Sydney Business Park - Stage 3 (SSD-10477)
Response to Submissions

Attachment A: Request for further information

# Staff Amenity Zones (Warehouse 1 - Level 2)

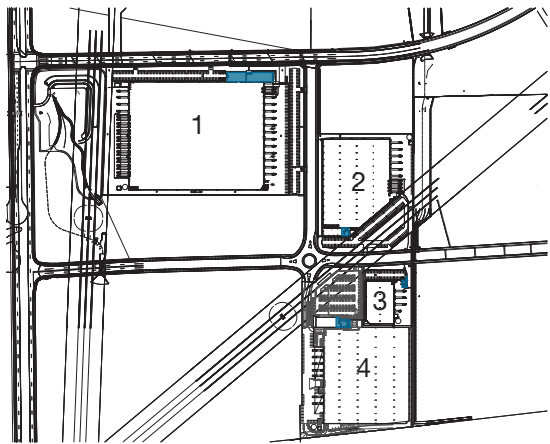
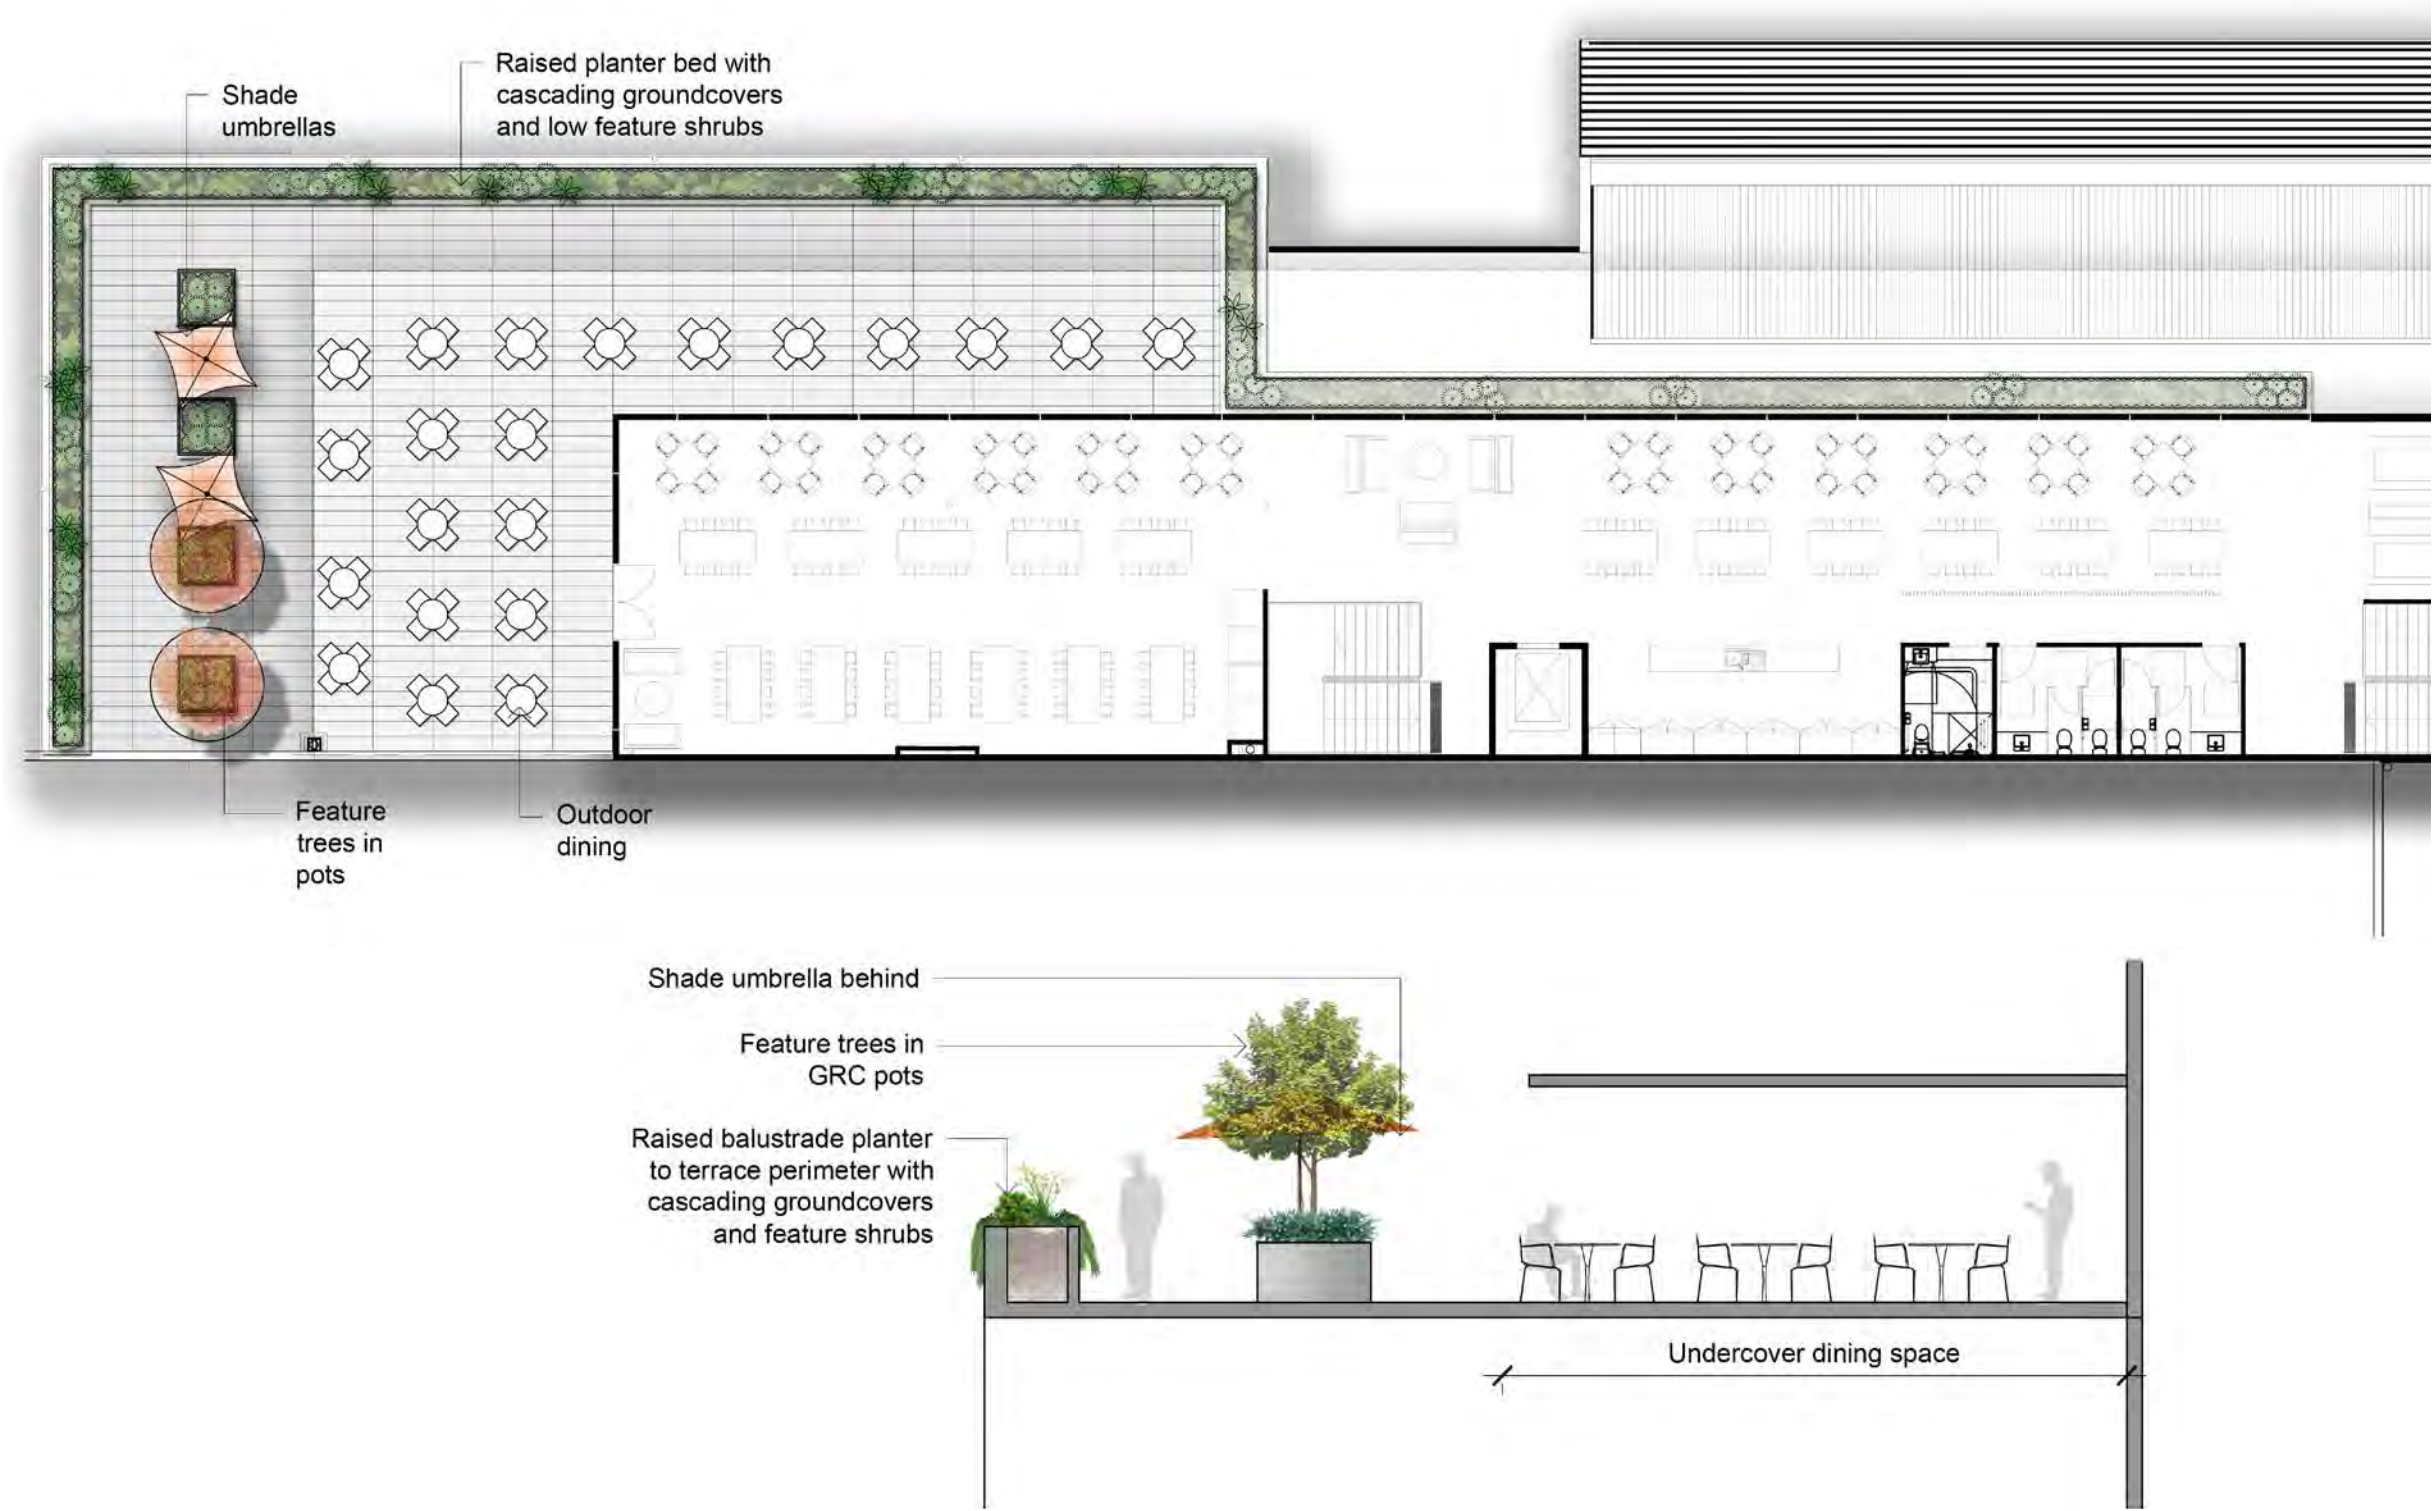
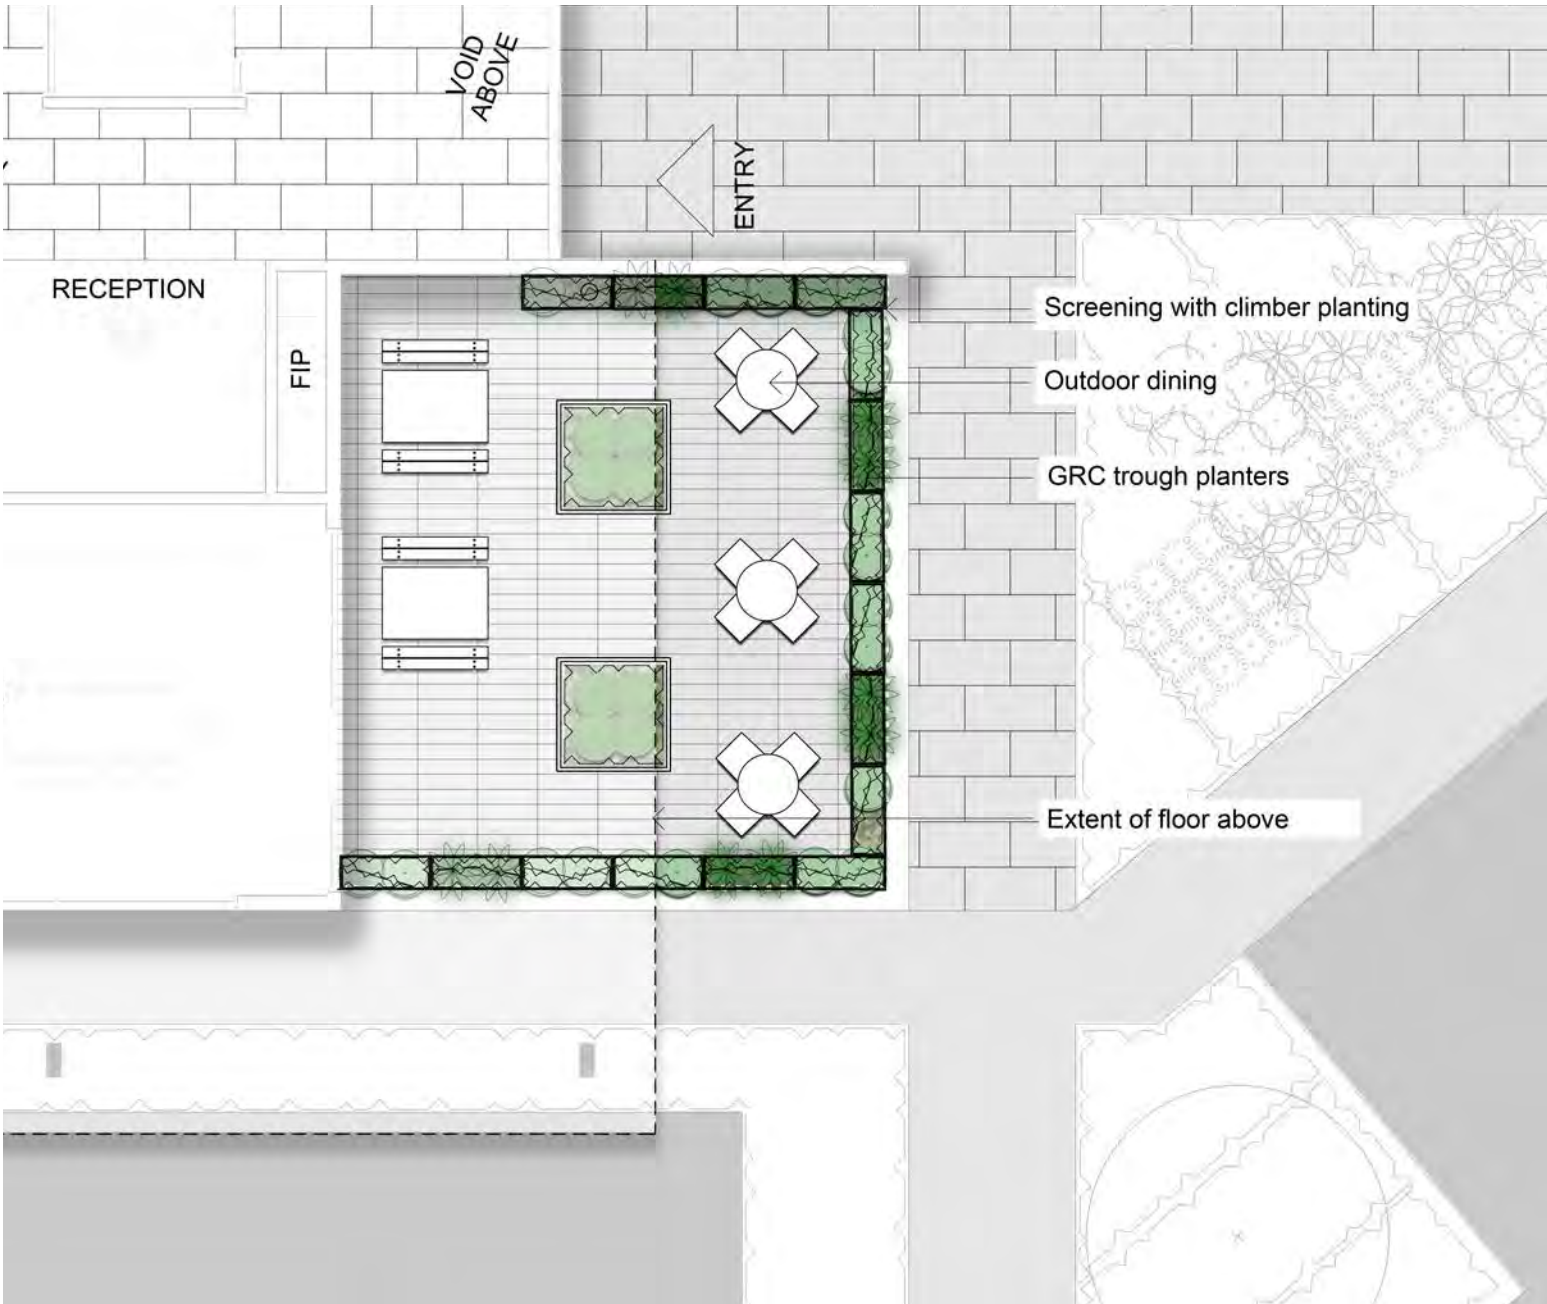
Please provide plans that demonstrate adequate useable open space is proposed for the operational staff for all four warehouses.
